From: Rael, Rudy E.
Sent: Wednesday, March 22, 2017 9:44 AM
To: 'David Soule (david@riograndeengineering.com)'
Subject: 6300 Petirrojo NW

Based upon the information provided in your submittal received 3/21/17, the above referenced Grading and Drainage plan dated 3/20/17 cannot be approved for Grading Permit or Building Permit until the following comments are addressed:

Project Title: 6300 PETIRROO NW Building Permit #: City Drainage #: D10D0003FB
DRB#: EPC#: Work Order#: A
Legal Description: lot 13 block 10 volcano cliffs UNIT 22
City Address: ~~6004 KIMMICK~~ 6300 Petirroo NW

ENGINEER'S SEAL  3/20/17 DAVID SOULE P.E. #14522	6300 PERIRROJO	DRAWN BY WCUJ
	GRADING AND DRAINAGE PLAN	DATE 3-20-17
 Rio Grande Engineering 1808 CENTRAL AVENUE SE SUITE 201 ALBUQUERQUE, NM 87108 (505) 872-0888		21721-LAYOUT-3-20-17
		SHEET #
		JOB # 21721

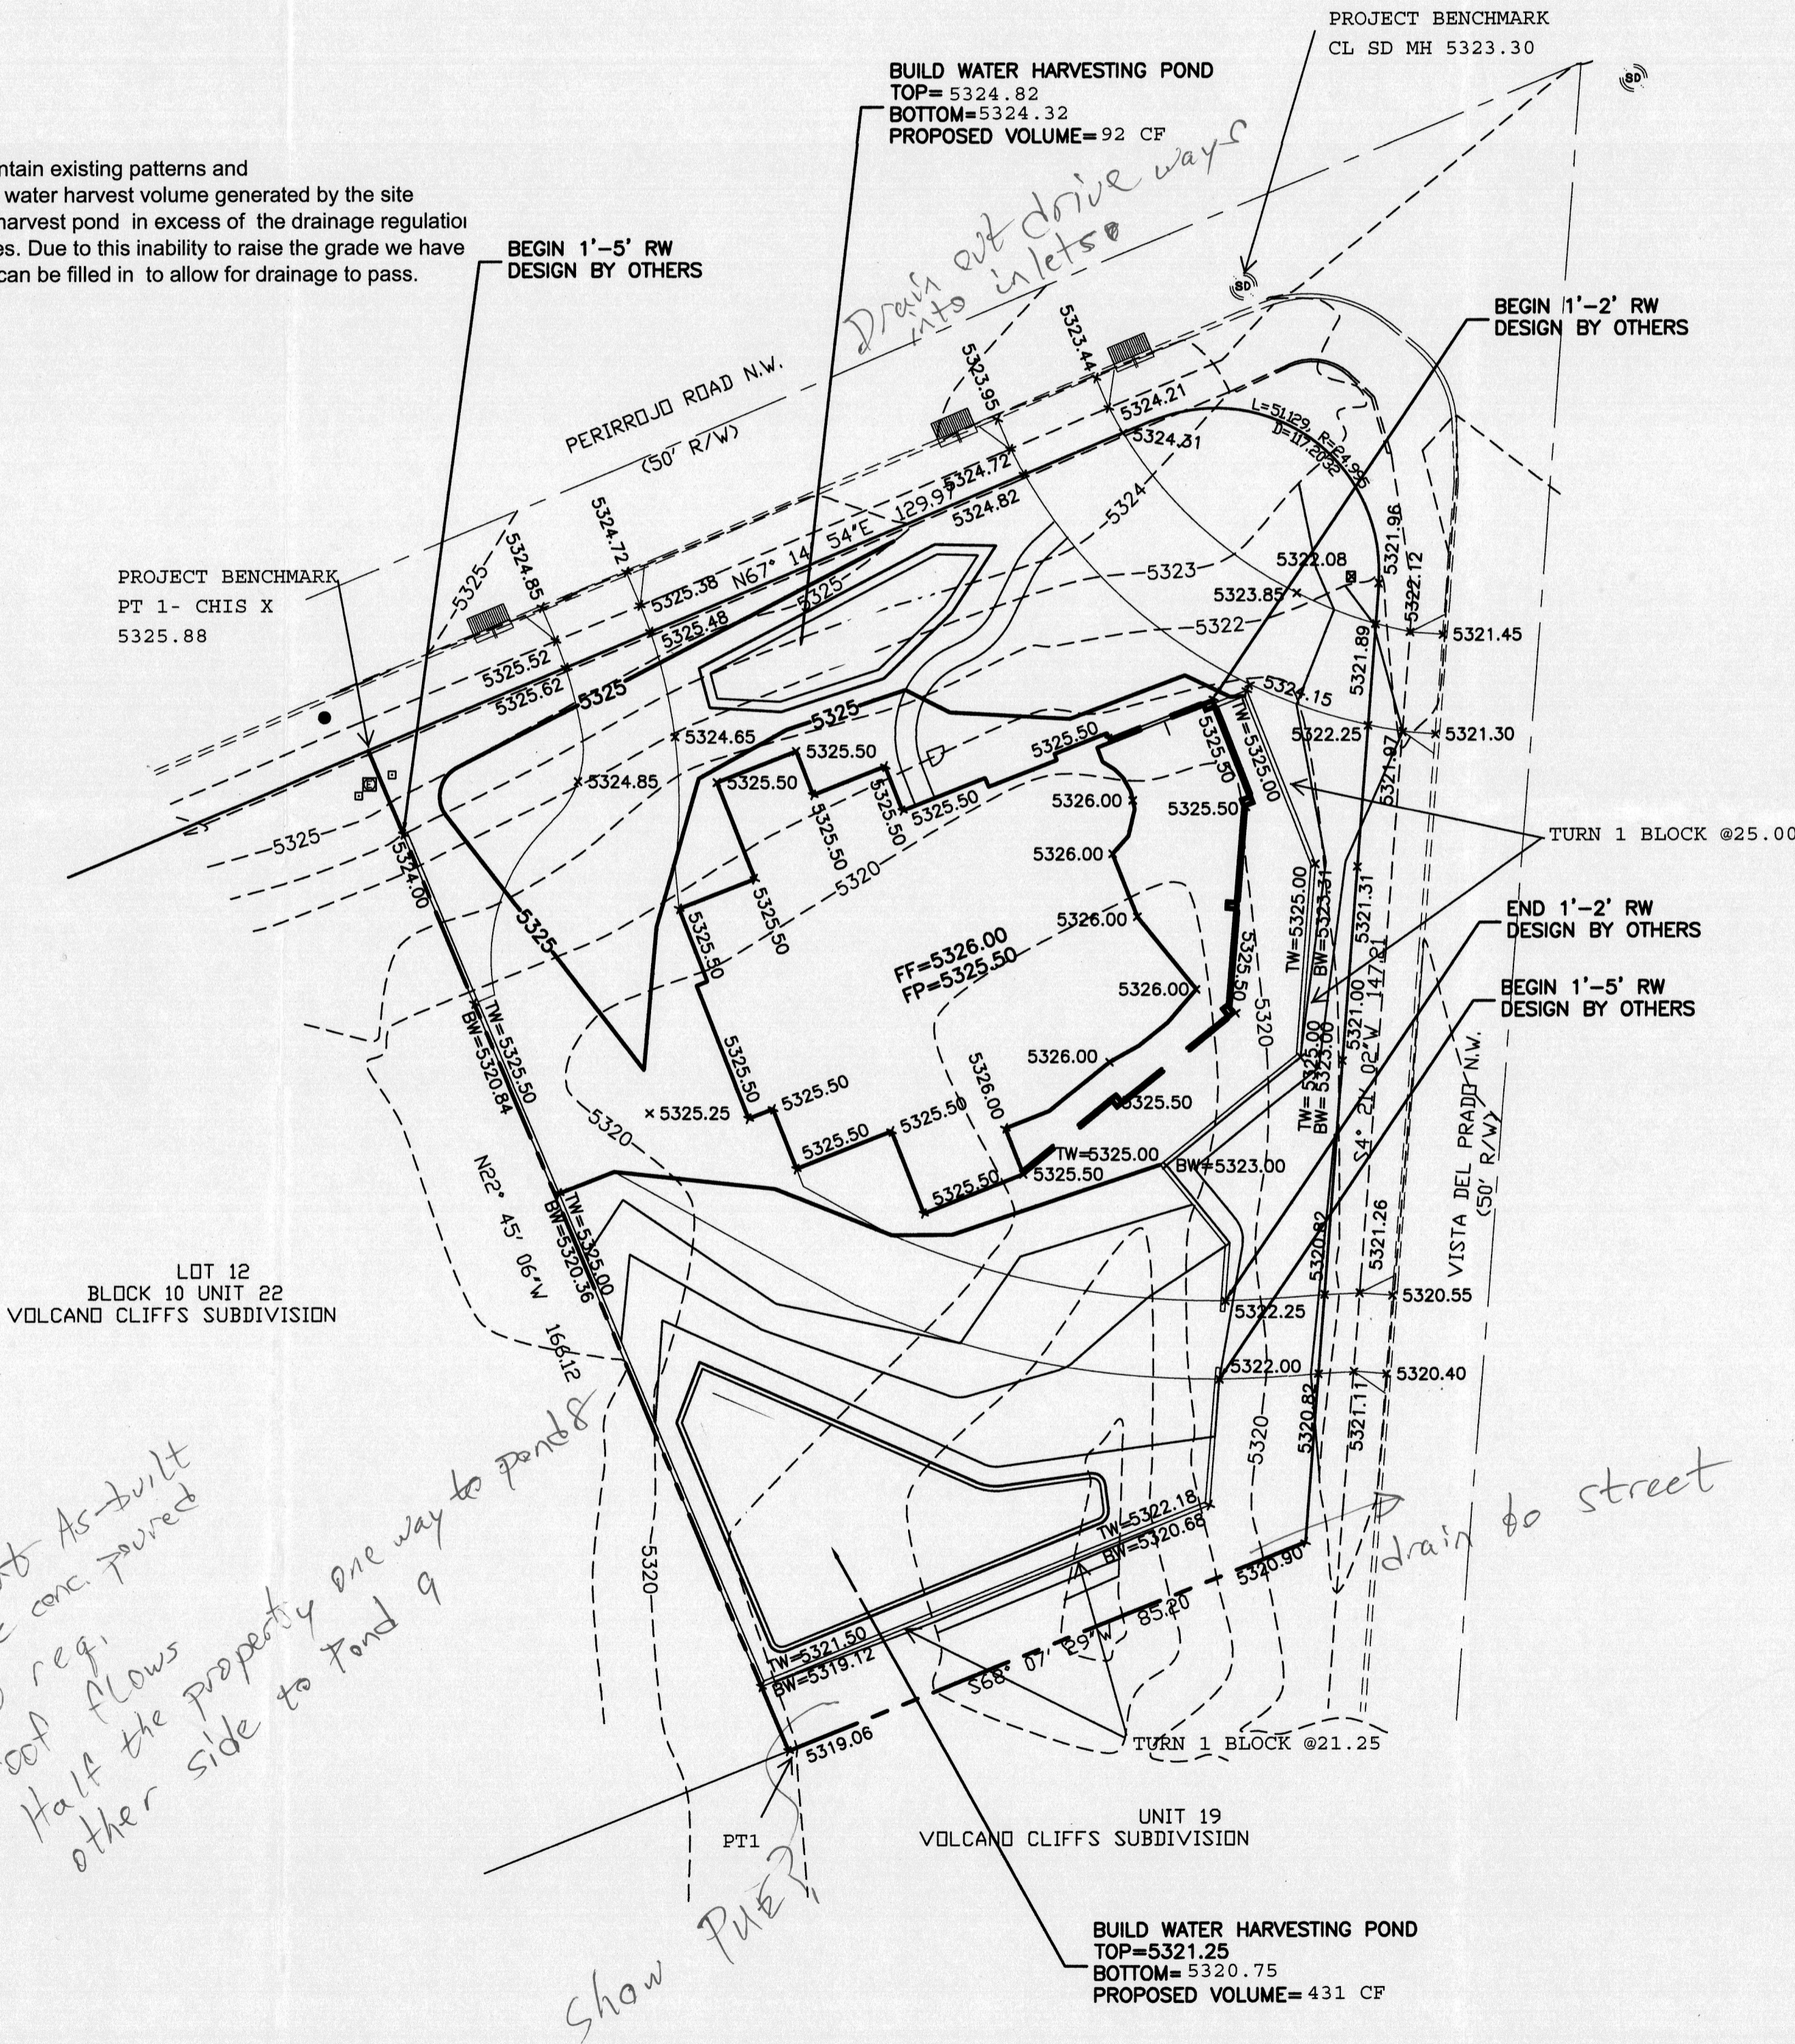
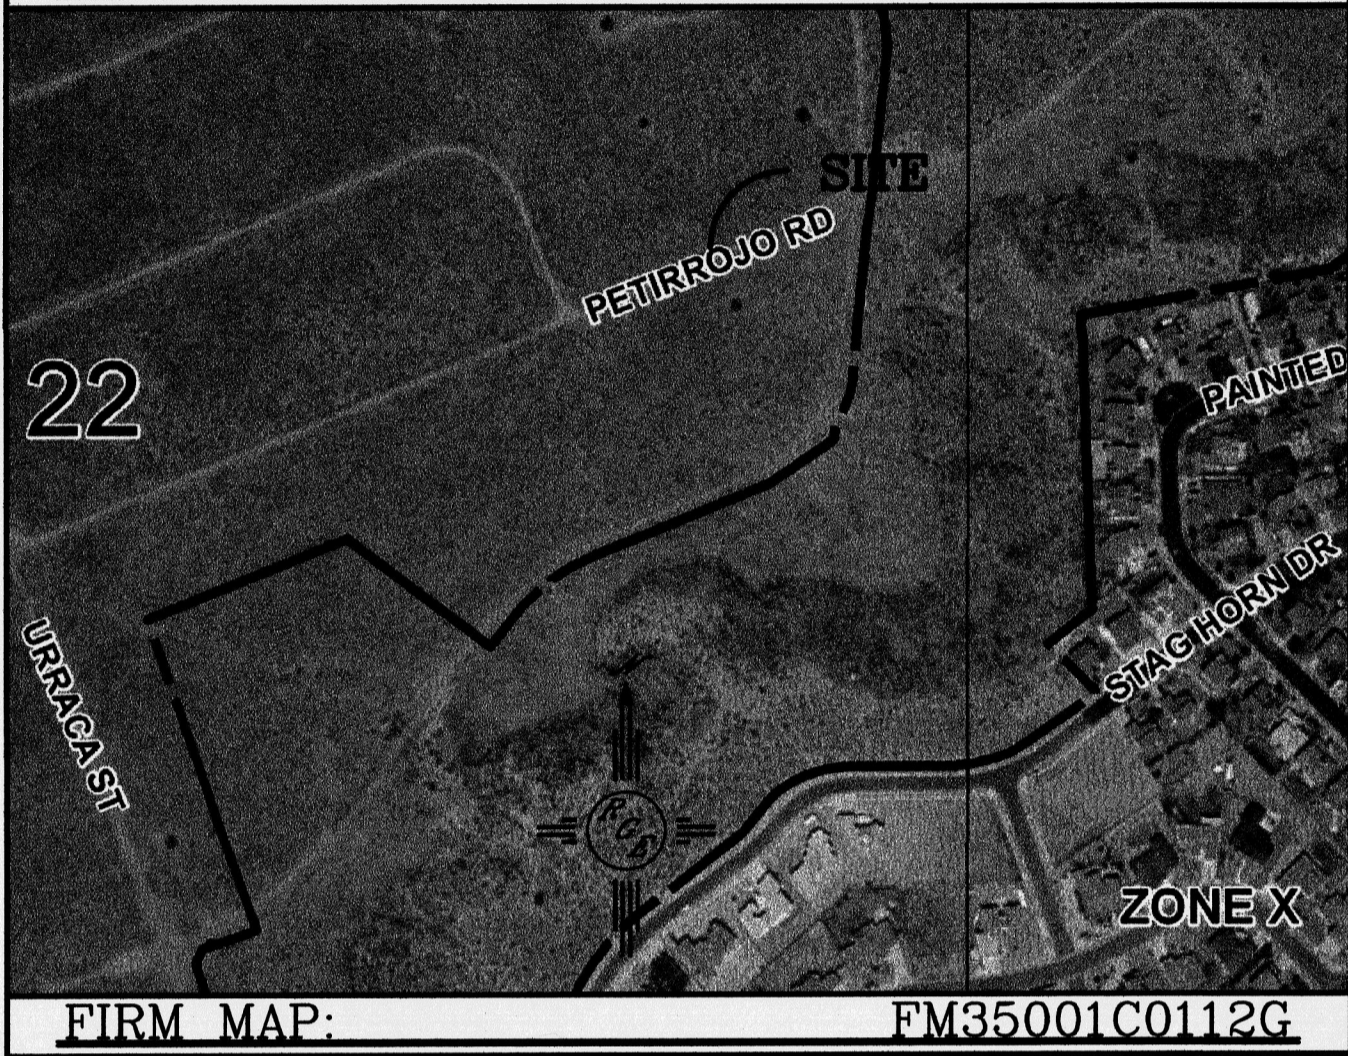
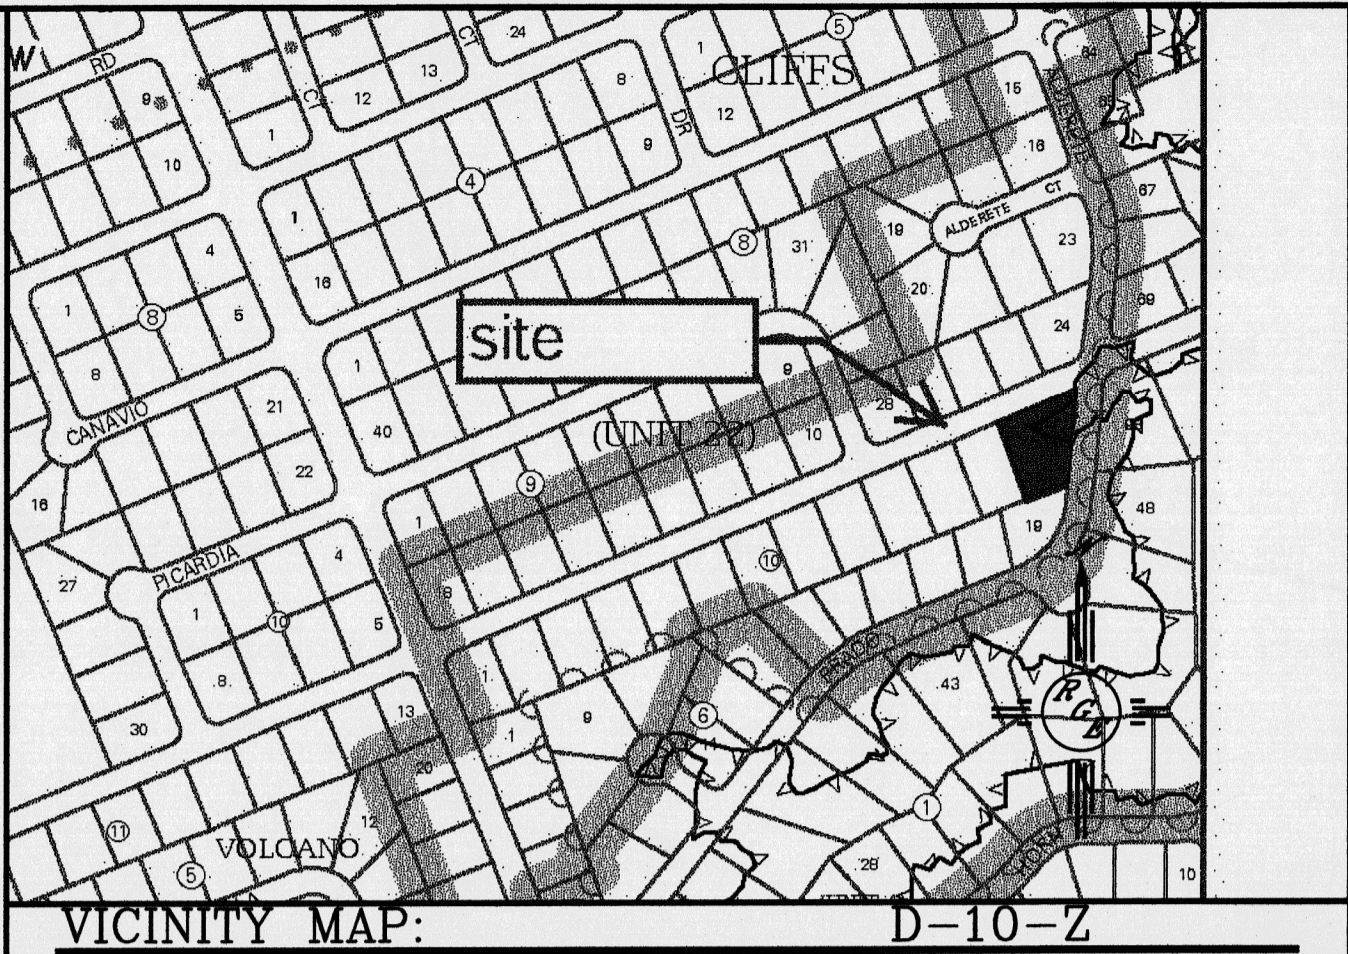
- Provide a statement explaining retaining walls require a separate permit and this plan must be followed and supplied during the permitting process.
- Provide the 10' PUE.
- This lot drains to two separate ponds, provide the roof flows. Half the roof flows should drain to the North and the other half to the south.
The north half of this property should drain into Petirrojo street and into the inlets, which drain to pond 8.
- Provide a statement that a pad certification is required before building pad is poured. In Bolden letters if possible.
- Provide a bench mark reference.
